RE: Cork County Council Planning Register Reference – 14/557
An Bord Pleanála Reference – PL04.244439
Construction of a substation to replace substation previously granted under PL04.219620
and all ancillary site development works.
Barnadivane, Kneeves, Terelton, County Cork

Observations re planning appeal to An Bord Pleanála PL04.244439

LANDSCAPING PLAN

RING BUSBAR CONFIGURATION
1 LINE BAY & 2 TRAF0 BAYS & SPACE
FOR 5 FUTURE BAYS & 2 WING COUPLERS

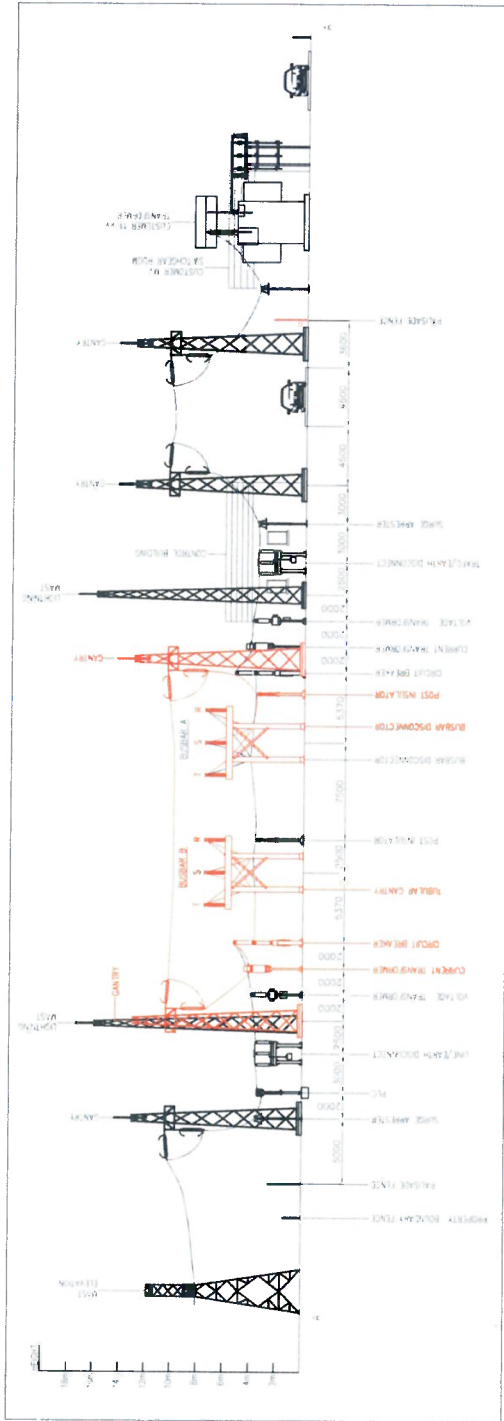
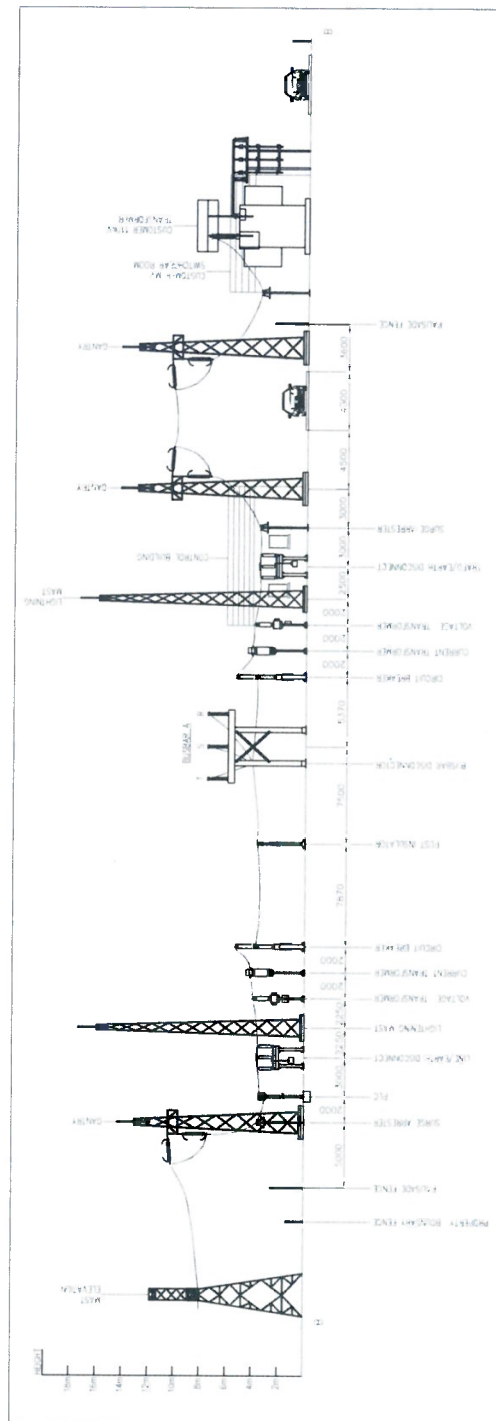
The only evidence which the applicant has produced from the TSO, either ESB or Eirgrid, is a 110kv – AIS substation building plan and elevation that appears to be lifted from some website. to demonstrate the need for the proposed increase in the scale and capacity of the substation from that already permitted in connection with the permitted wind farm at this location. These plan and elevation drawings have actually been provided by Arran Wind Farm Ltd and are not as a result of a direct correspondence with Eirgrid and do not fulfill the proofs necessary to satisfy the

request for further clarification by the Bord. There are in fact other options open to the applicants with regard to the design and layout of this substation, for example a GIS 110KV substation which would be considerably smaller than the AIS model. Also the area for expansion is something which can be negotiated with Eirgrid. The rigid regulations regarding the size and layout of a 110kv substation that are supposedly being imposed by Eirgrid are something that the Bord needs to clarify through direct communication with Eirgrid.
